# SITE DEVELOPMENT PLAN

## LOT 2, GREATER EUROPE MISSION SUBDIVISION FILING NO. 1

SITE DEVELOPMENT PLAN  
**MONUMENT STEEL STRUCTURES**  
 COVER SHEET  
 18910 BASE CAMP ROAD  
 MONUMENT, COLORADO

# Site Development Plan\_v1-redline.pdf Markup Summary

SITE DEVELOPMENT PLAN
MONUMENT STEEL STRUCTURES
BUILDING ELEVATIONS AND FLOOR PLANS
18910 BASE CAMP ROAD
MONUMENT, COLORADO

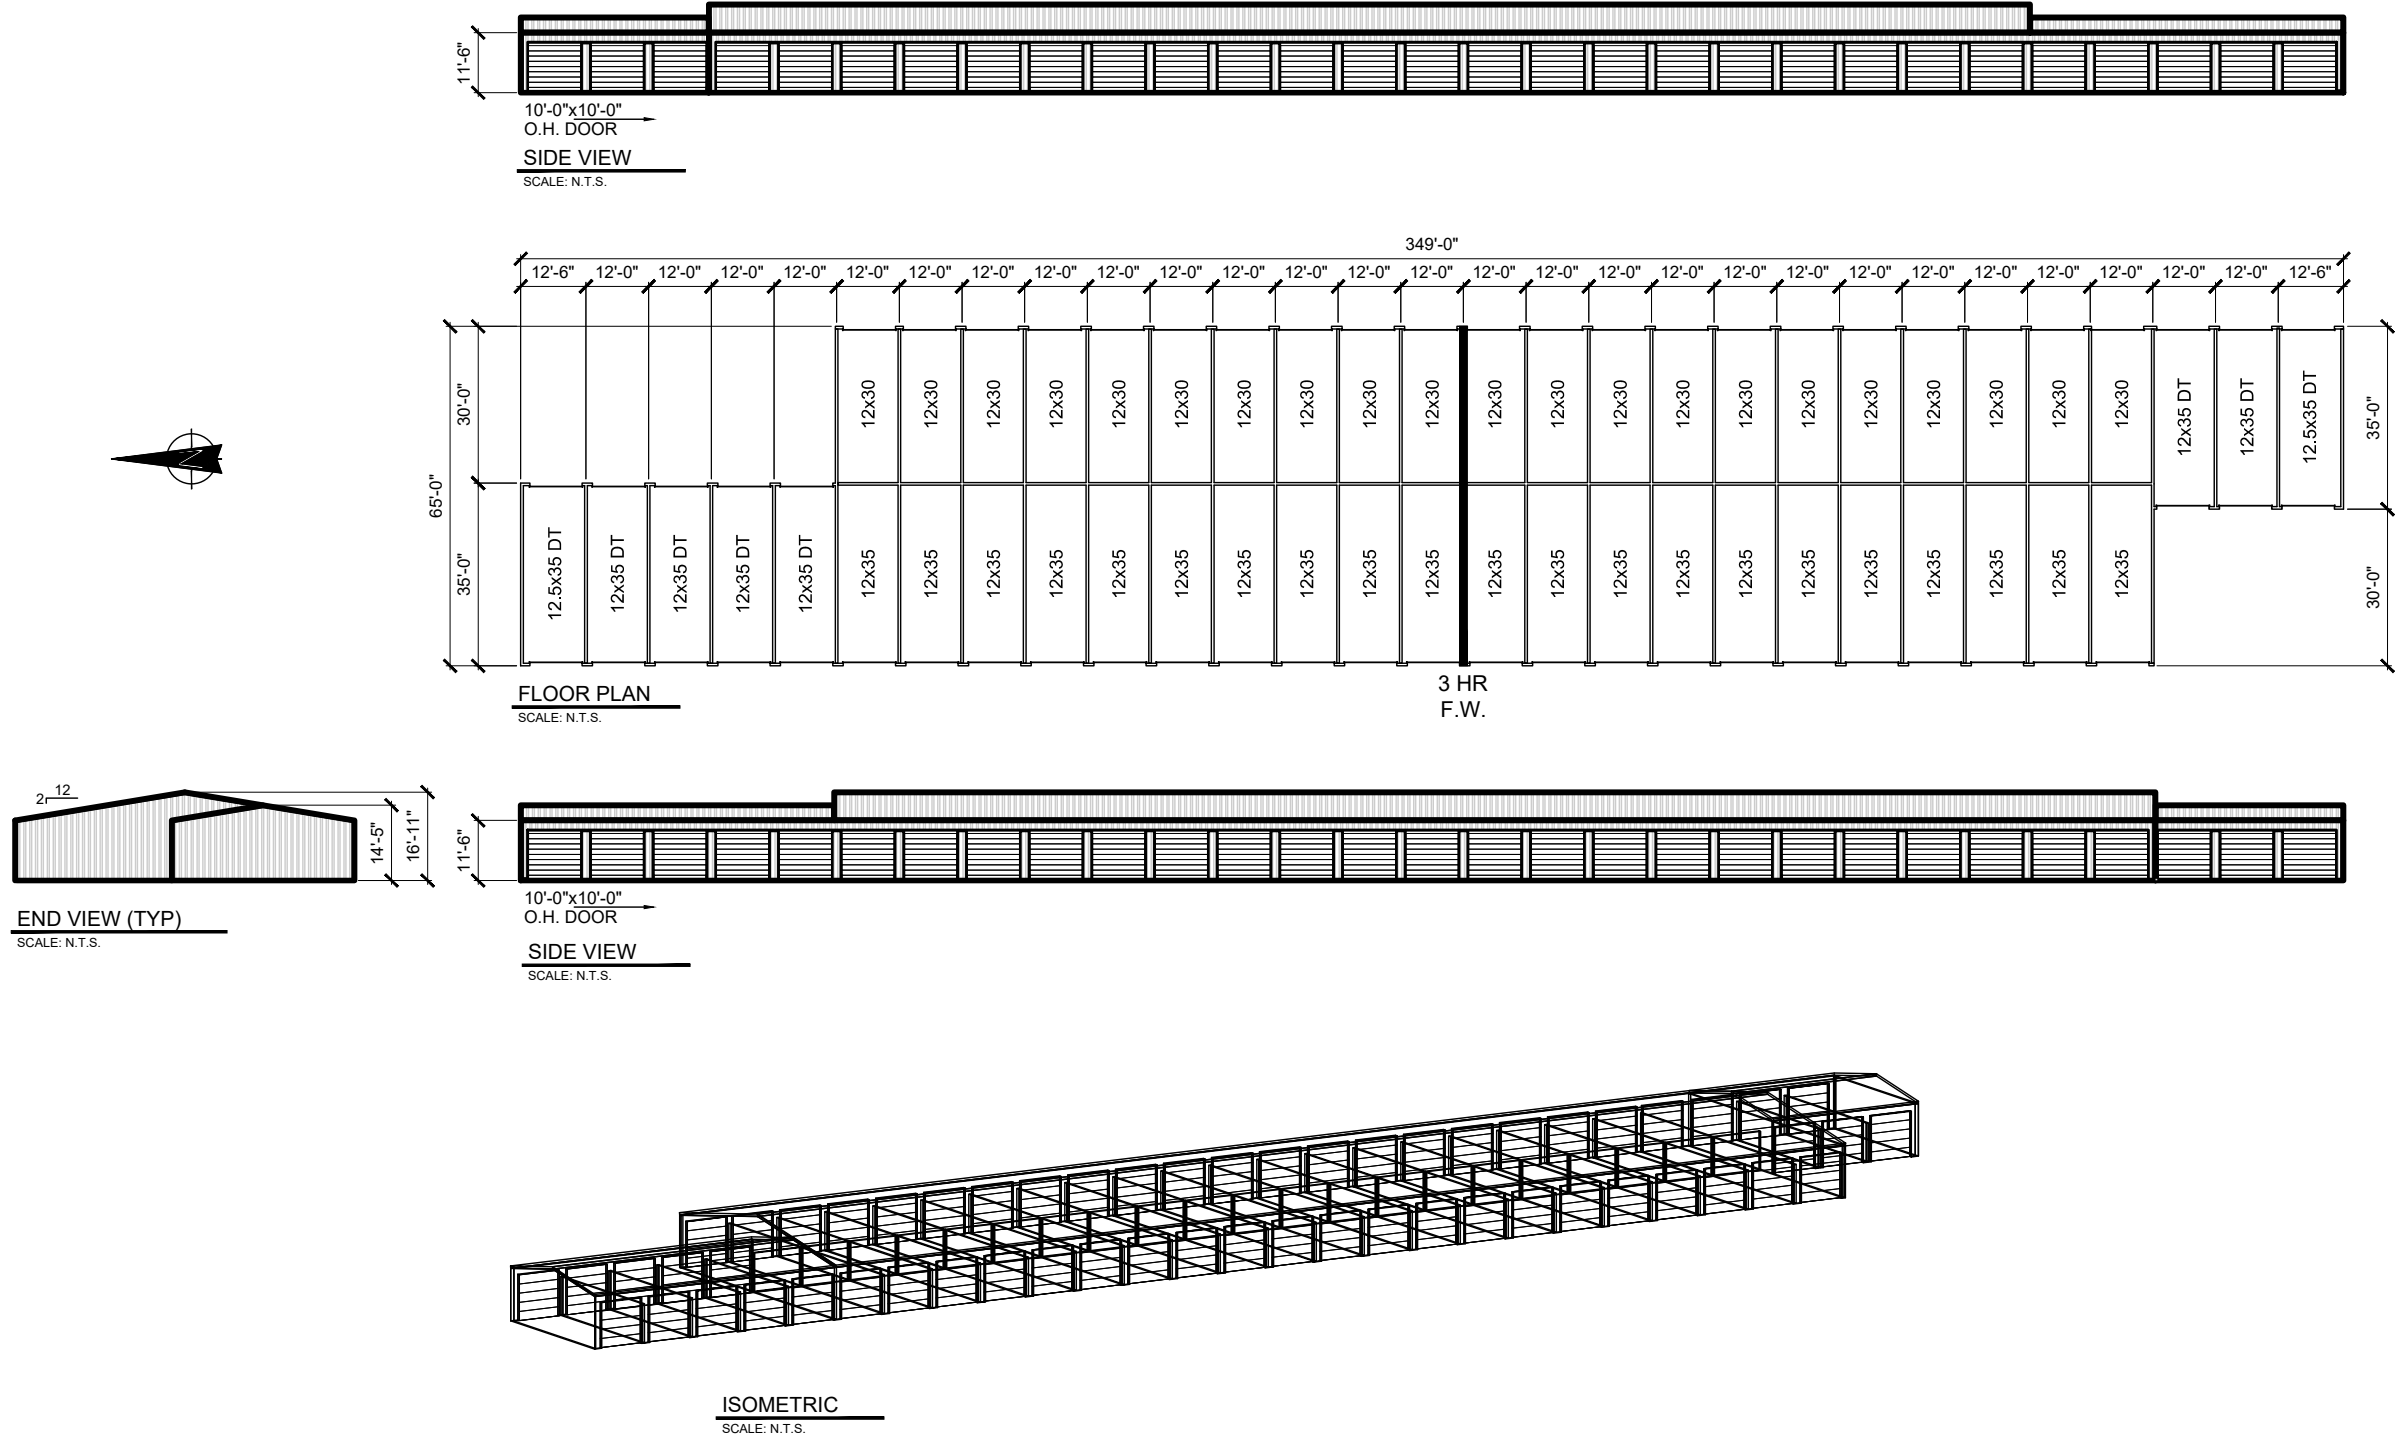
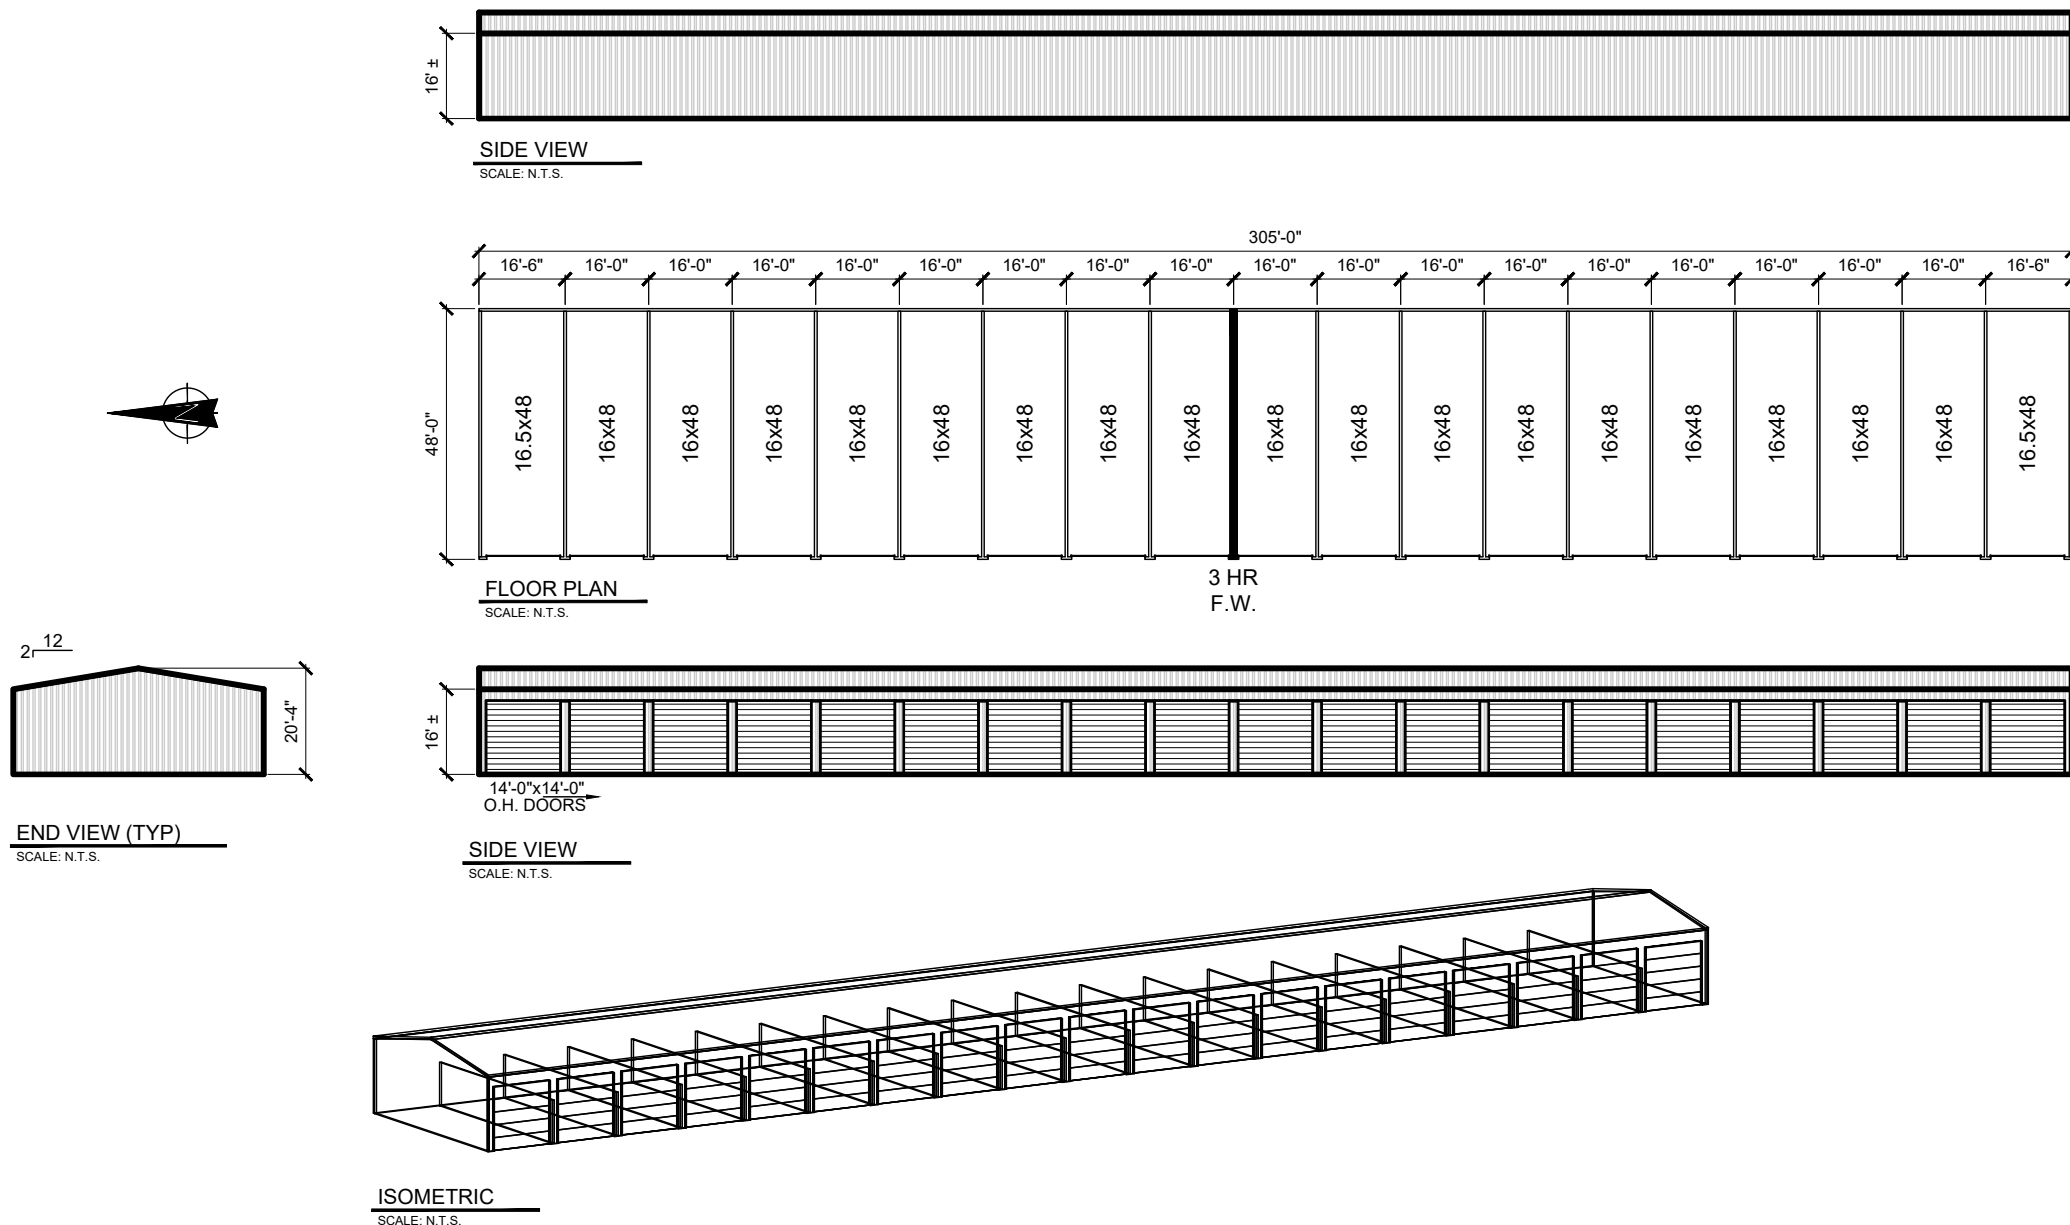
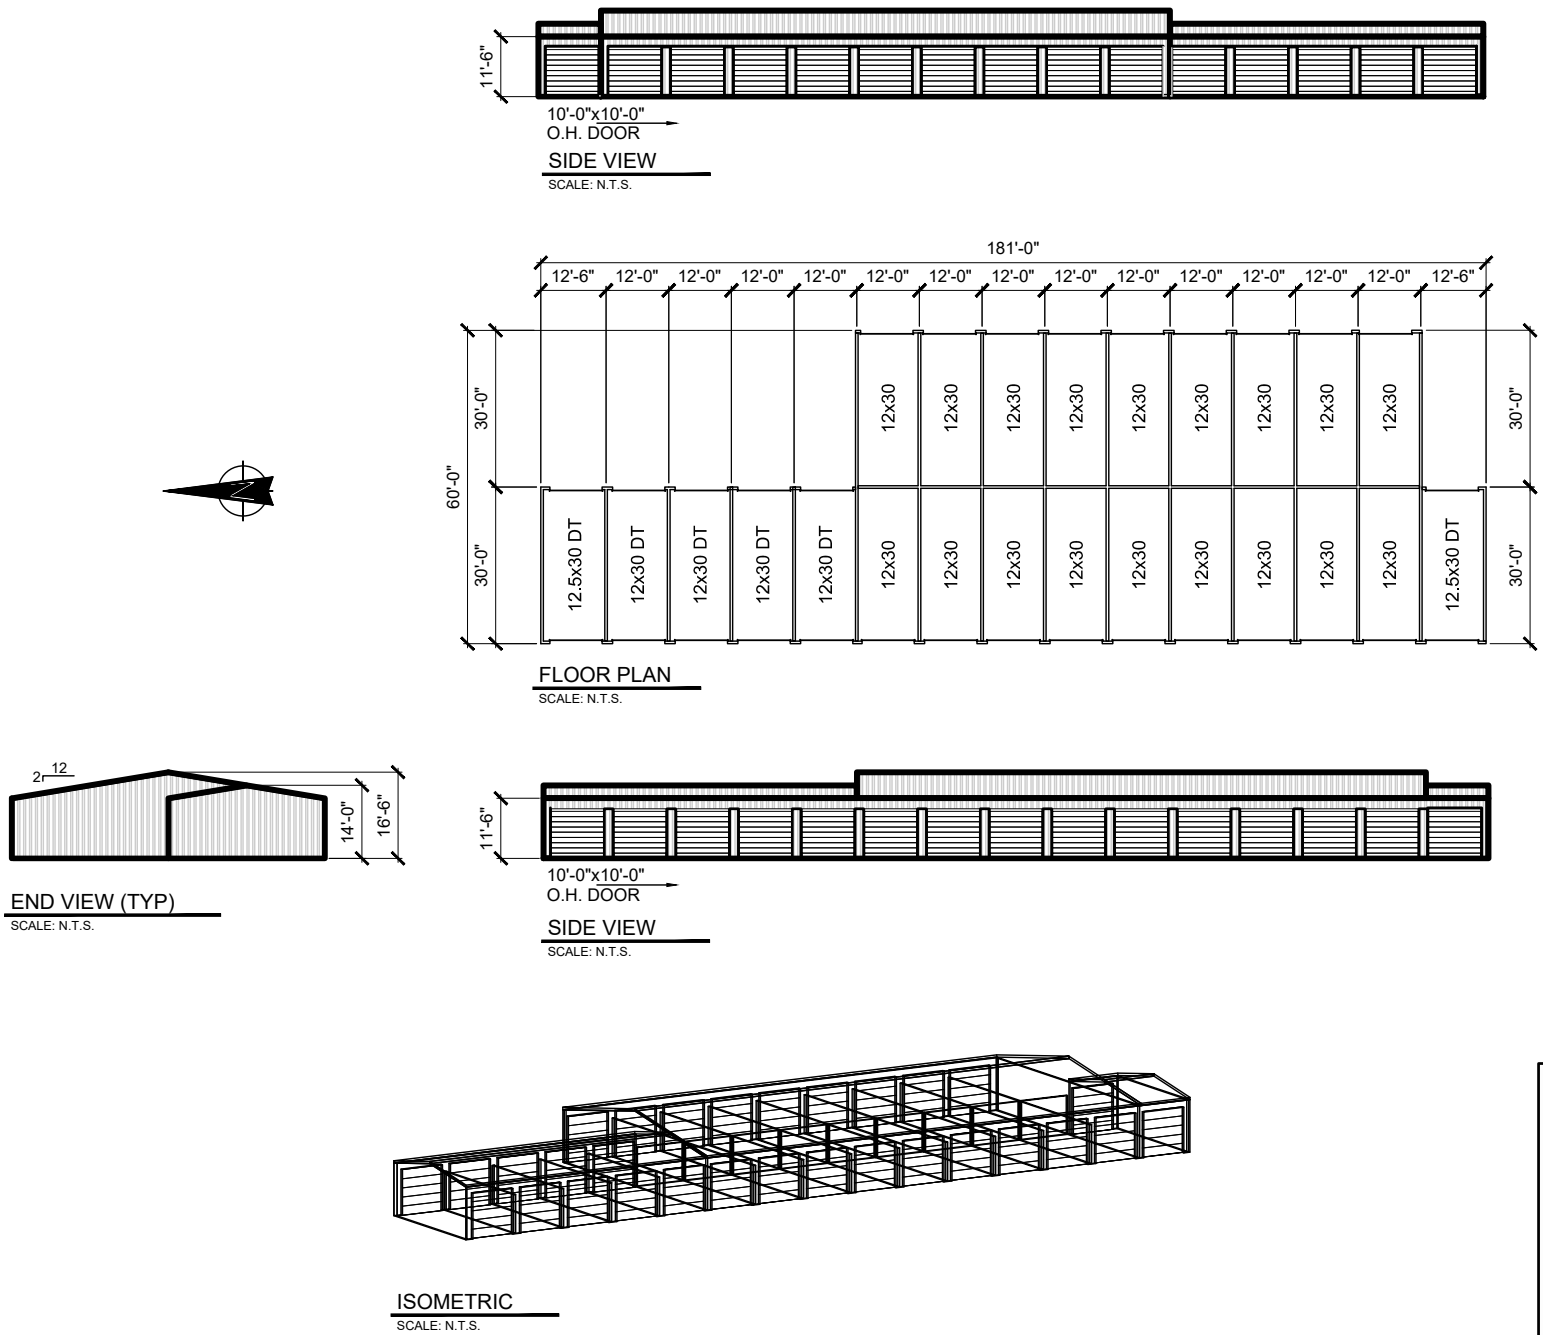
Include floor plan dimensions on floor plans in order to calculate parking ratio.
